EPC STORMWATER REVIEW COMMENTS  
IN ORANGE BOXES WITH BLACK TEXT

## Flying Horse North Filing No. 5 Stormwater Management Plan (SWMP)

October 2025

**SF2427**

SHEET GEC 3

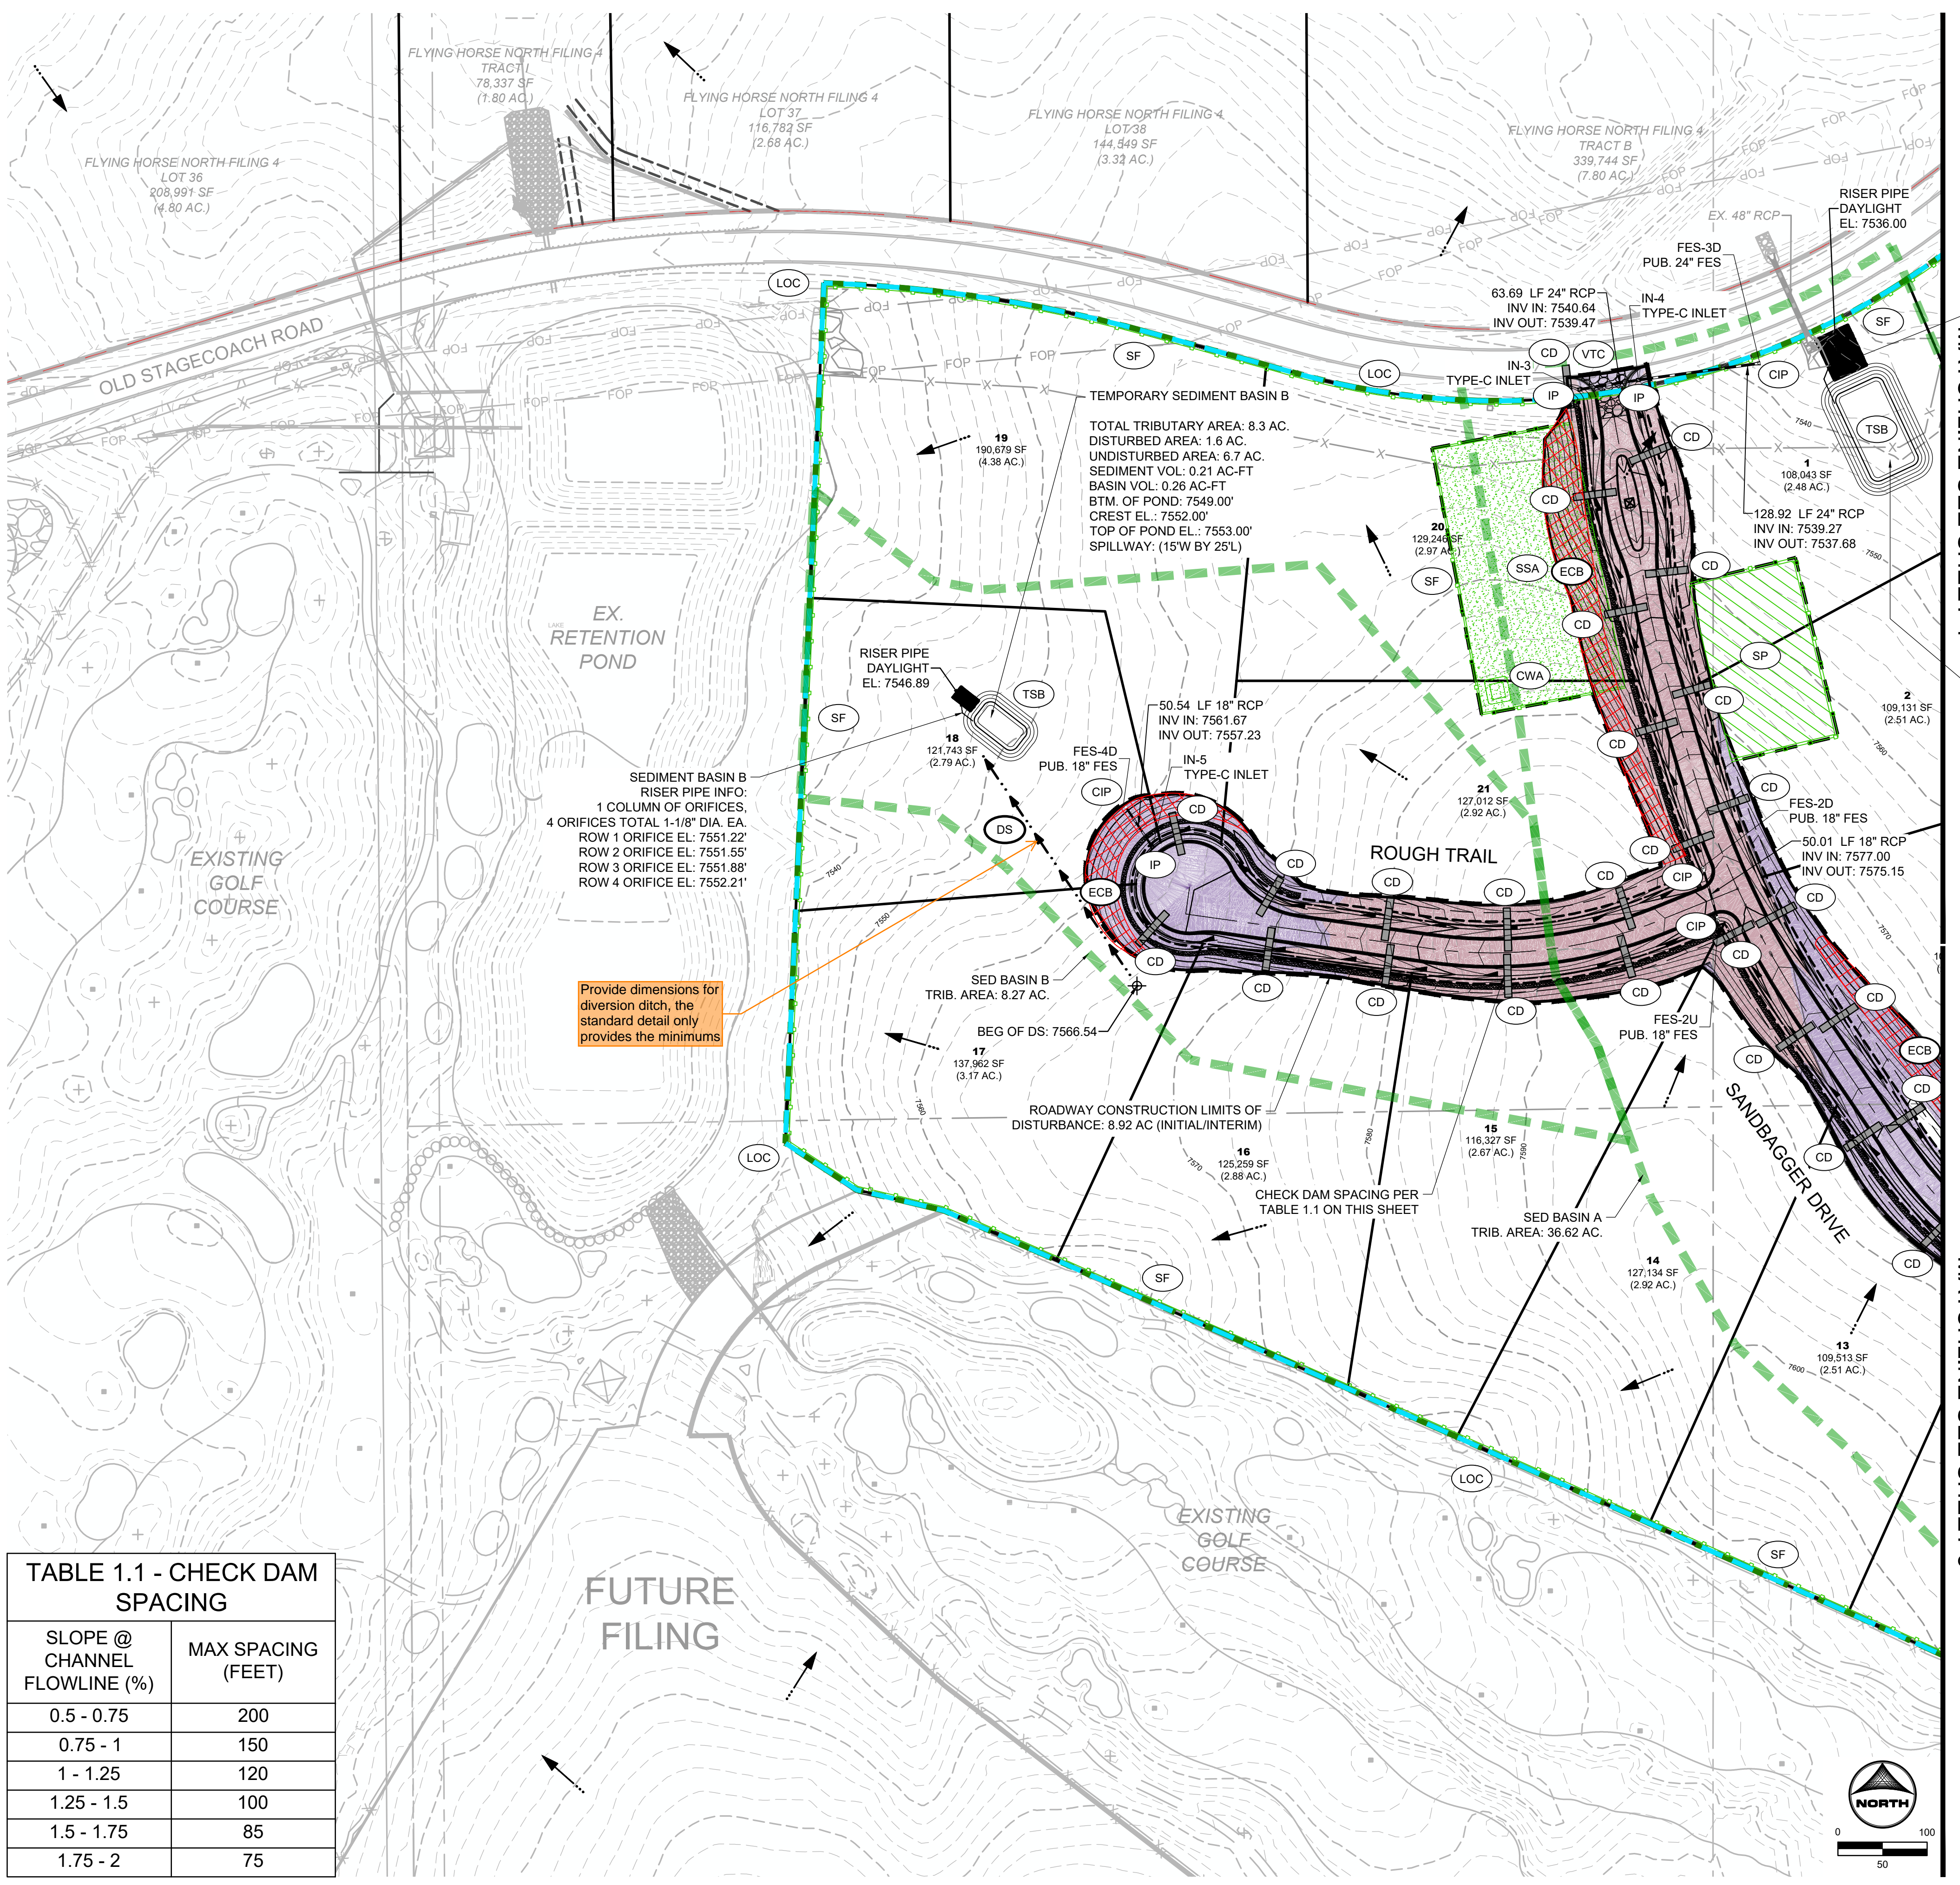
Please clarify. Is "proposed ponds" referring to Temporary Sediment Basin A & Temporary Sediment Basin B per GEC plan pg. 3?
